5 Blaydon Road (extension)

Application for Single Storey Side Garage

Proposed Ground Floor Plan
Scale 1:100

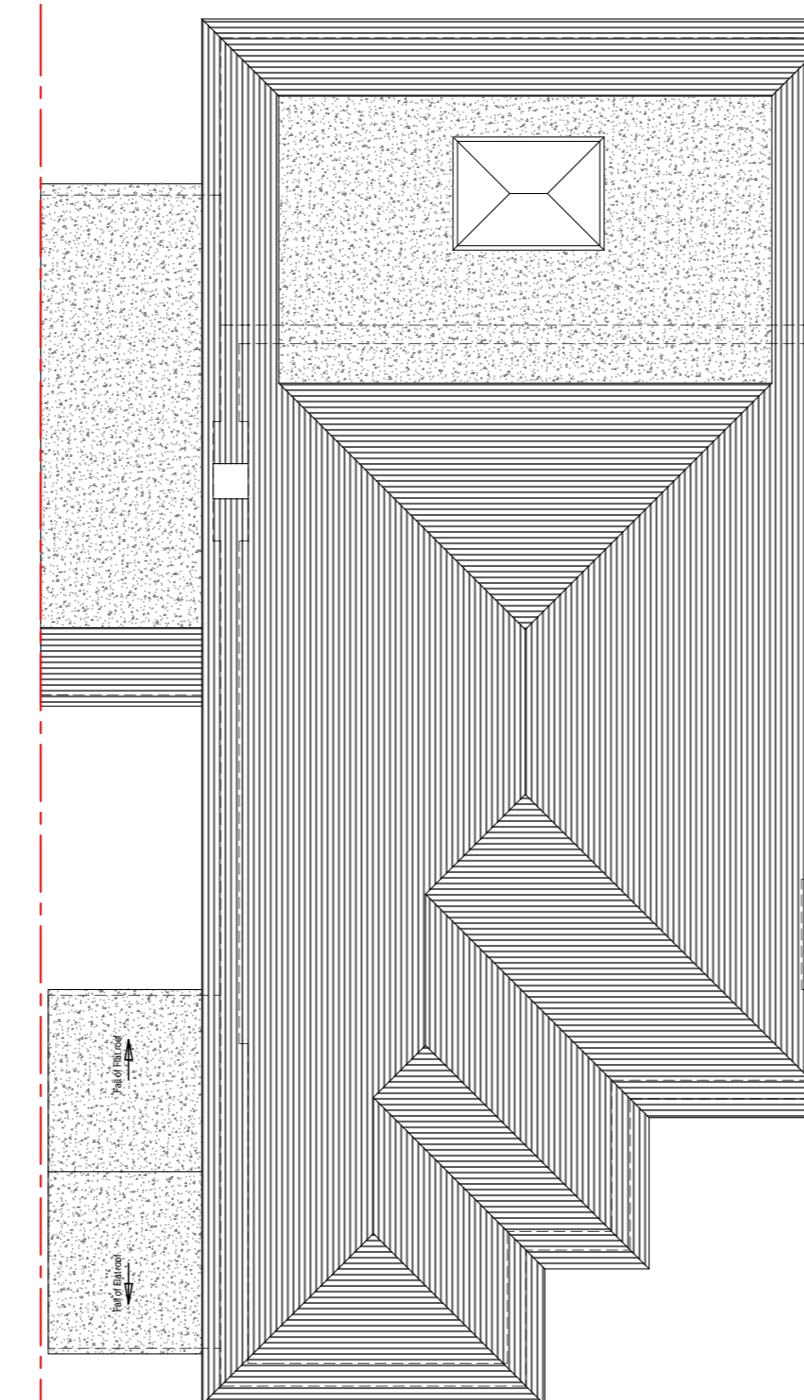
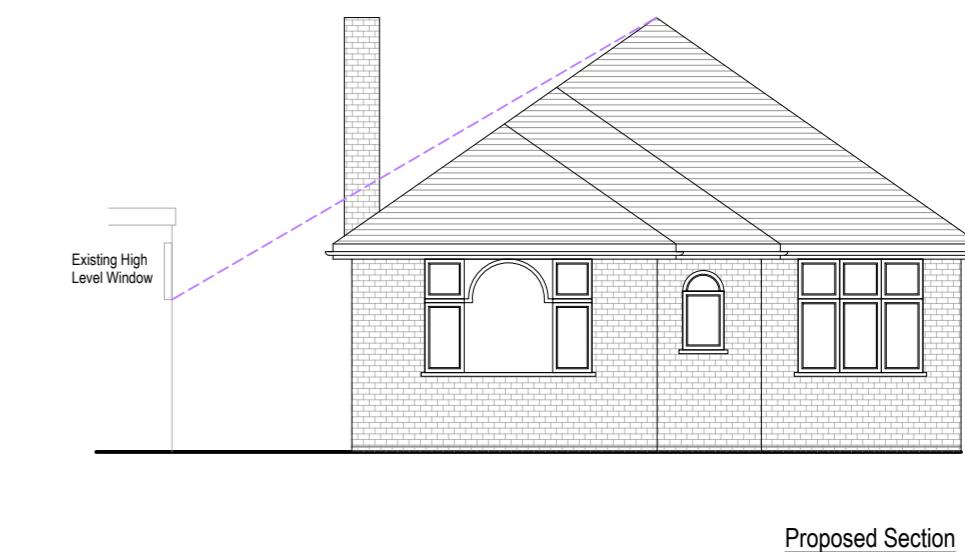
2) Proximity to Neighbour.

Please see plans which show we intend to leave 100mm gap between the flank wall of no 7 and no 5 new proposed Garage.

A setback has been created from main front wall of house.

Proposed Roof Plan
Scale 1:100

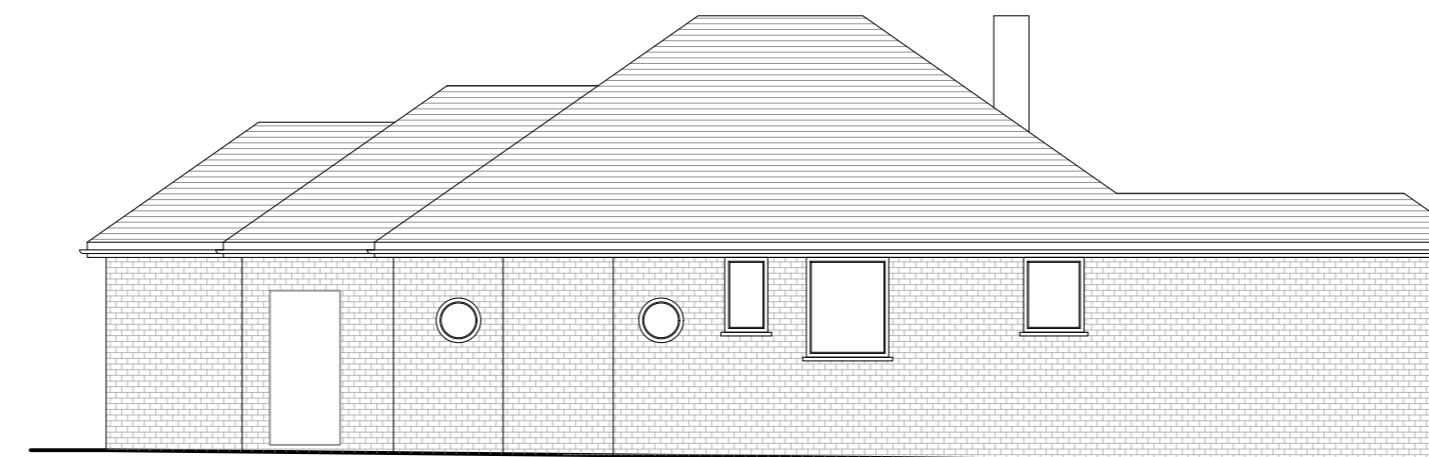
4) Drainage

It is proposed the Garage roof has a gutter on rear wall and front wall, the water from garage roof will be taken away into down pipes and then into the Surface water Drainage System.

This has been indicated on the plans for clarity.

Proposed Elevation A
Scale 1:100

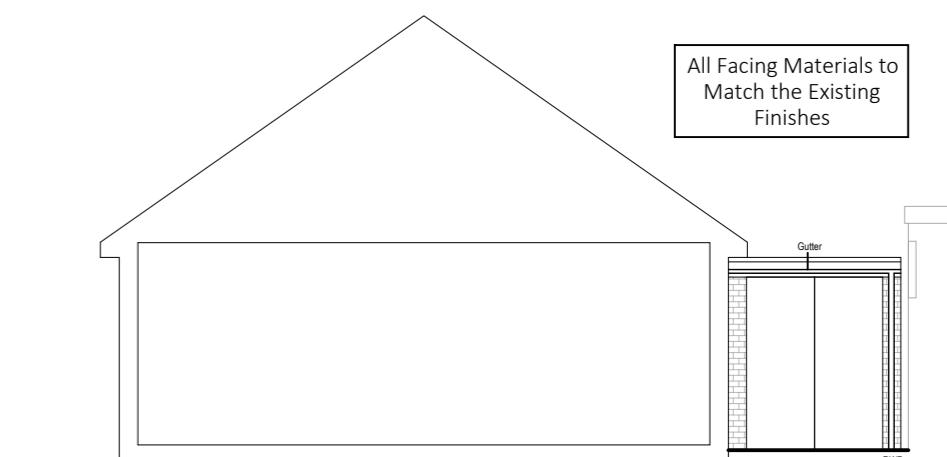
6) Height Differences

It is proposed garage roof will remain under the existing fascia as indicated on the plan.
